RE: 230 Martin Road, Badgerys Creek - Industrial Development (SSD-65529236)

Thank you for the opportunity to comment on the proposed State Significant Development (SSD-65529236) of two proposed warehouses at 230 Martin Road, Badgerys Creek Precinct, Western Sydney Aerotropolis.

LCC Comments RE: 230 Martin Road, Badgerys Creek

MASTERPLAN

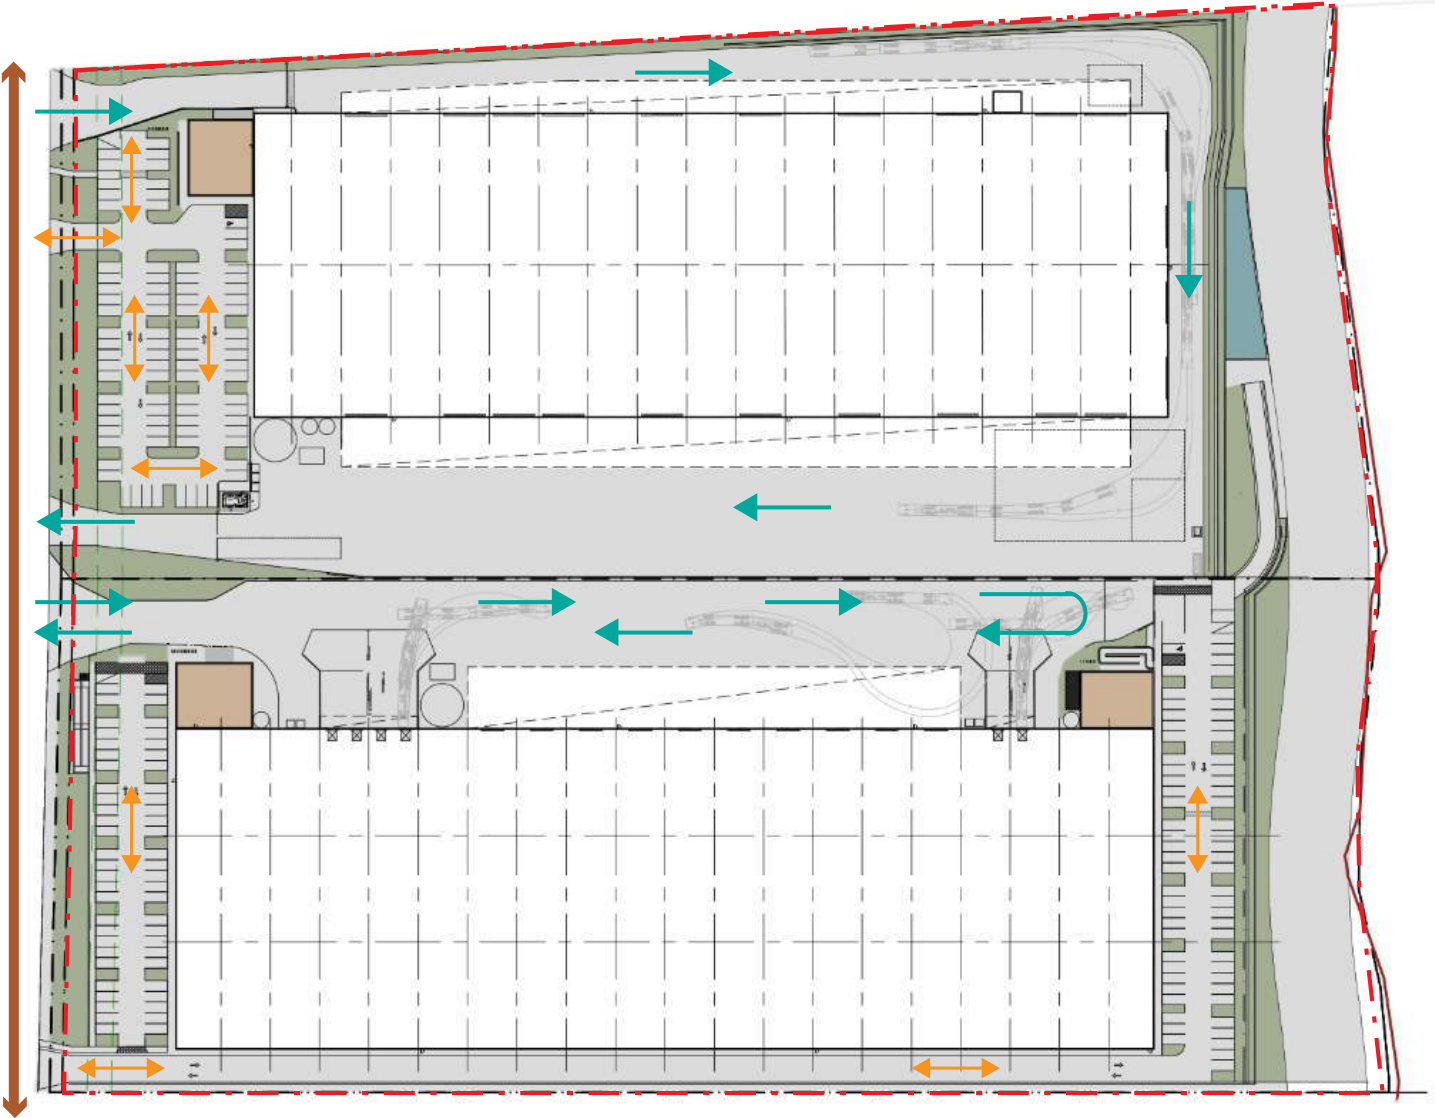
Include pedestrian-only access for the proposed warehouse two including them in all floor plans and landscape plans.

Warehouse 1 proposes two truck entrances plus car access. For pedestrians and active transport users' safety driveways must be consolidated, allowing the opportunity for increasing landscaping in the north and east boundaries.
